Rezoning Transportation Analysis
Petition Number: Insert Zoning Petition #2022-027
General Location Identifier: 18317703

Date	Description
07-28-2022	First Review (AO)

The petition is located on Sharon Road, a City-maintained major thoroughfare (Class III Commercial Arterial) in between Coltsgate Road, a City-maintained local street and Element Way, a private local street. The petition is located in the SouthPark Mixed Use Activity Center outside of Route 4, and within the limits of the SouthPark Small Area Plan.

SHEET NUMBER **RZ-1**

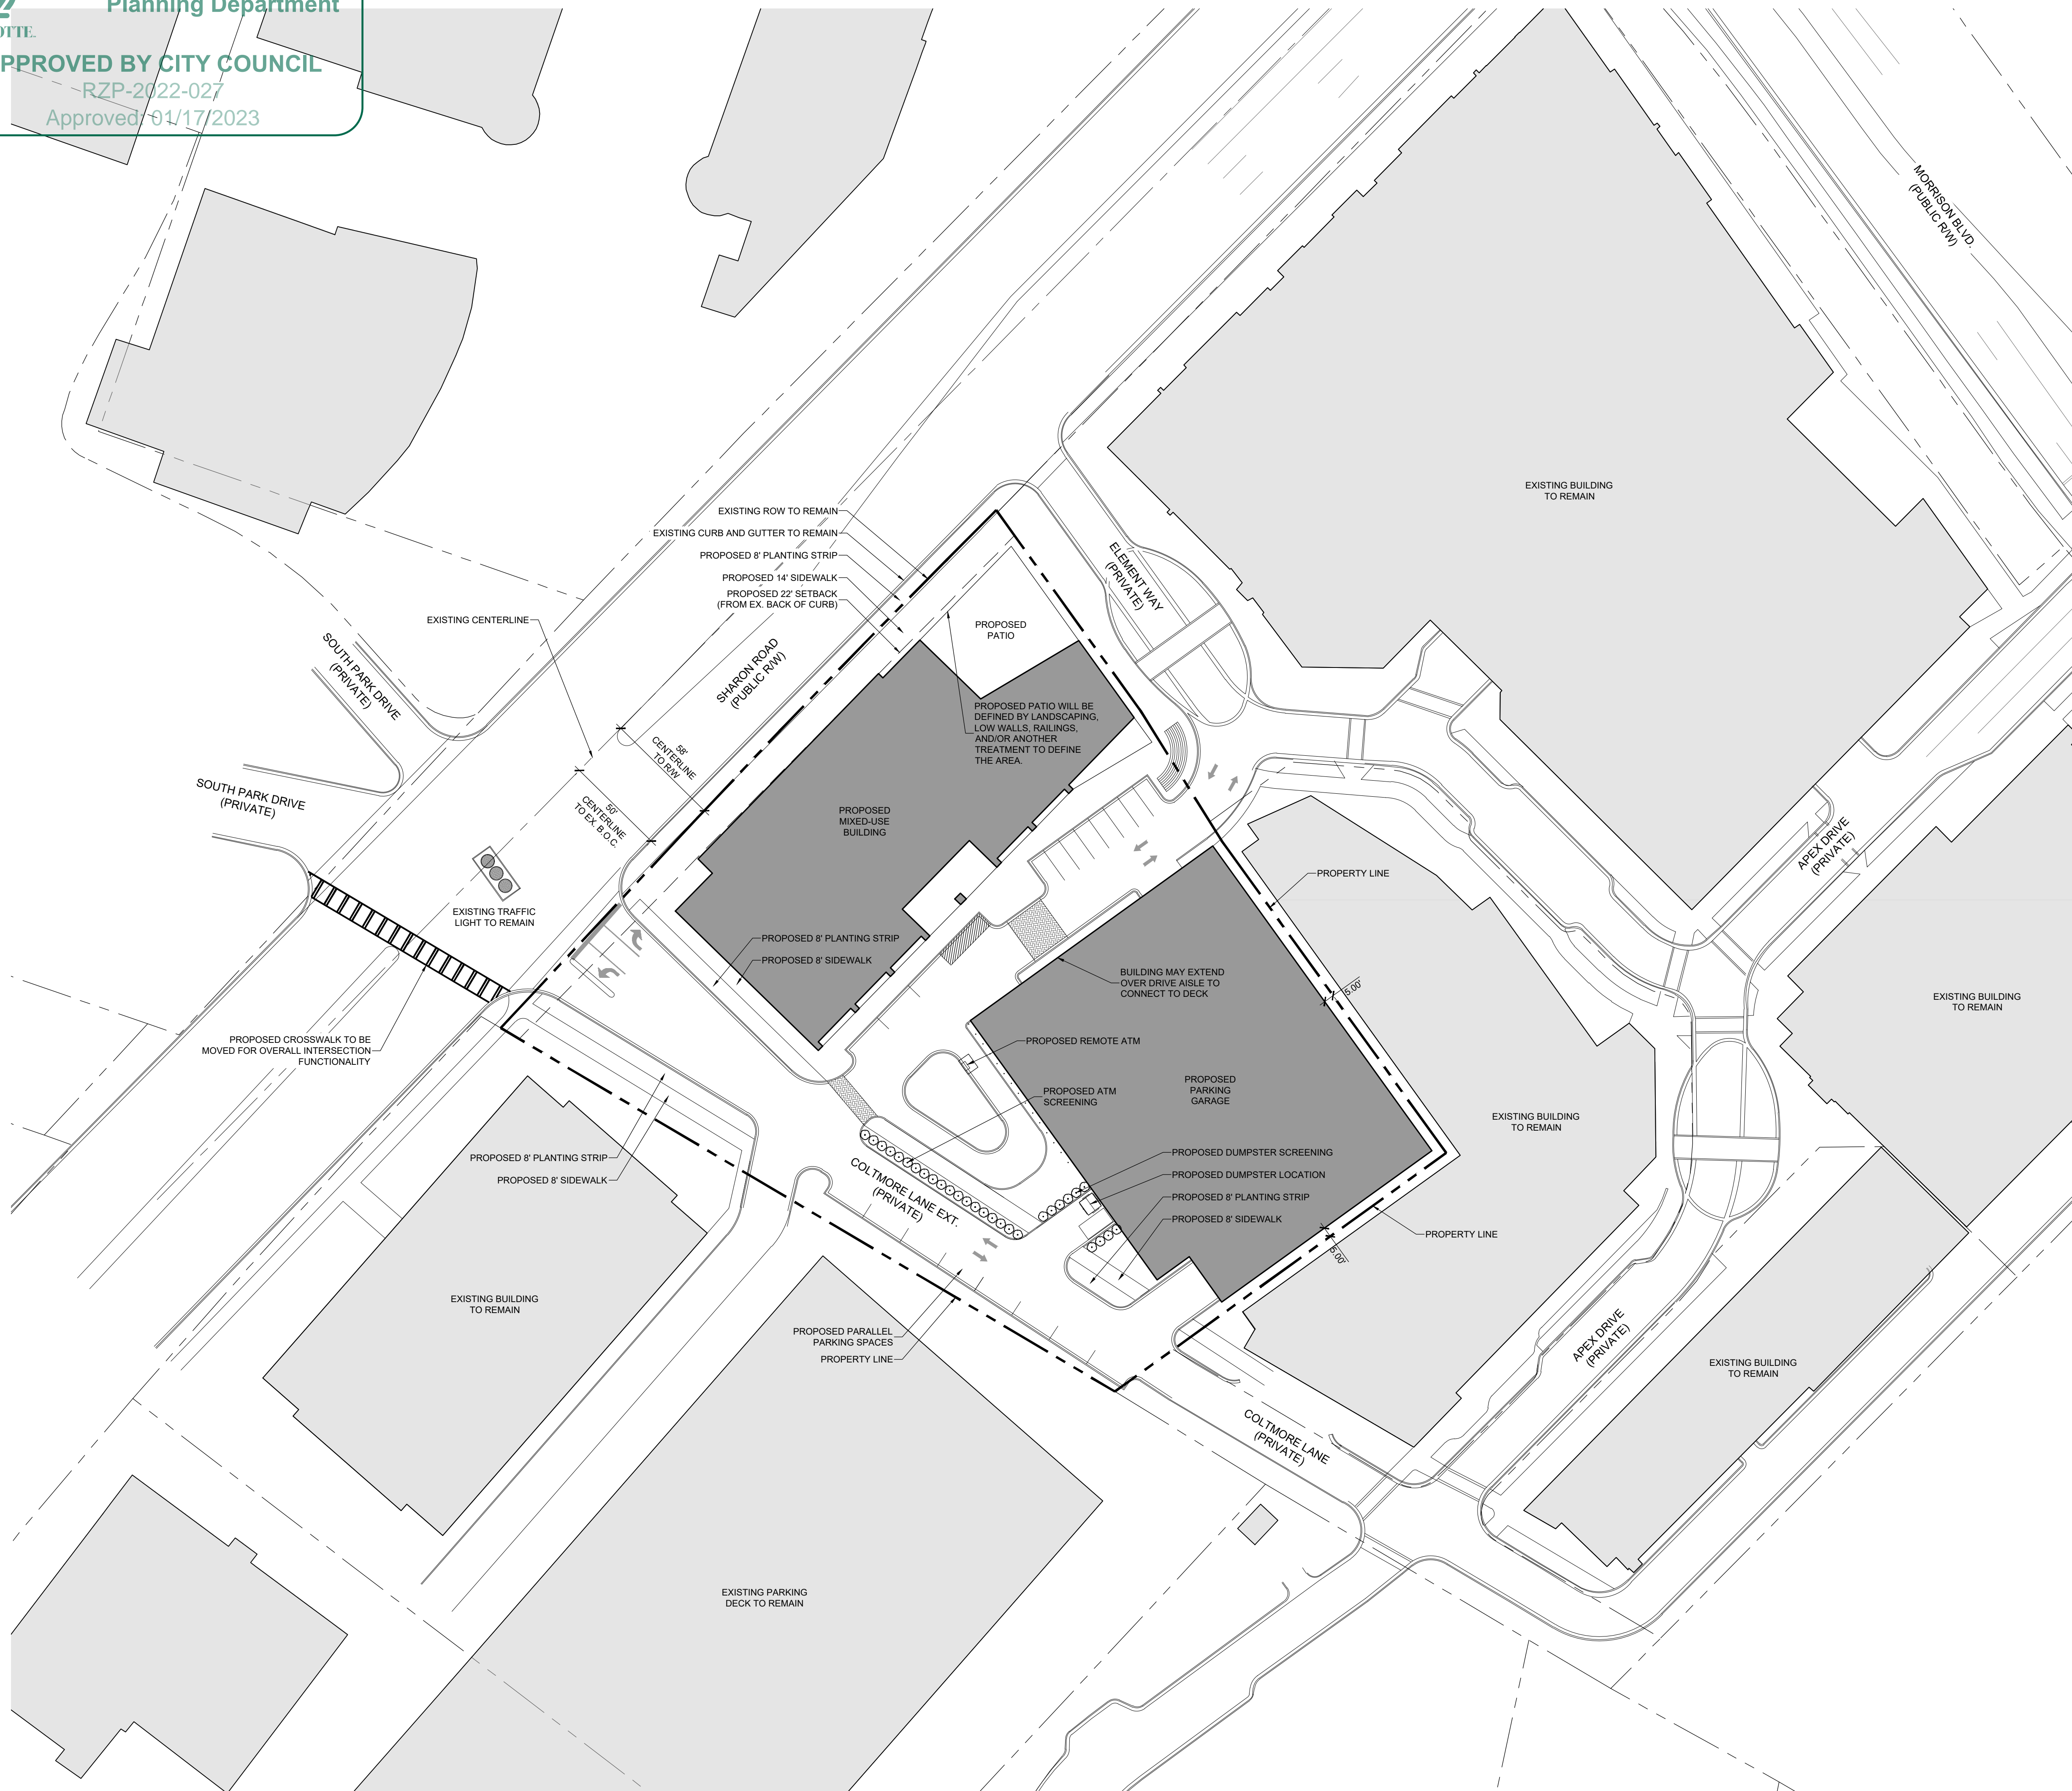
1. **Curbline:** The proposed zoning district has a setback measured from back of the existing or proposed future curbline.
 - a. **Sharon Road:** Future back of curb and gutter to be placed 44-feet measured from Sharon Road centerline.

Label and dimension the curb and gutter from the centerline for each road on the site plan.

3. Revise site plan and conditional note(s) to commit to dedicating right-of-way from the road centerline. The site plan shall label and dimension the right-of-way from the road centerline.
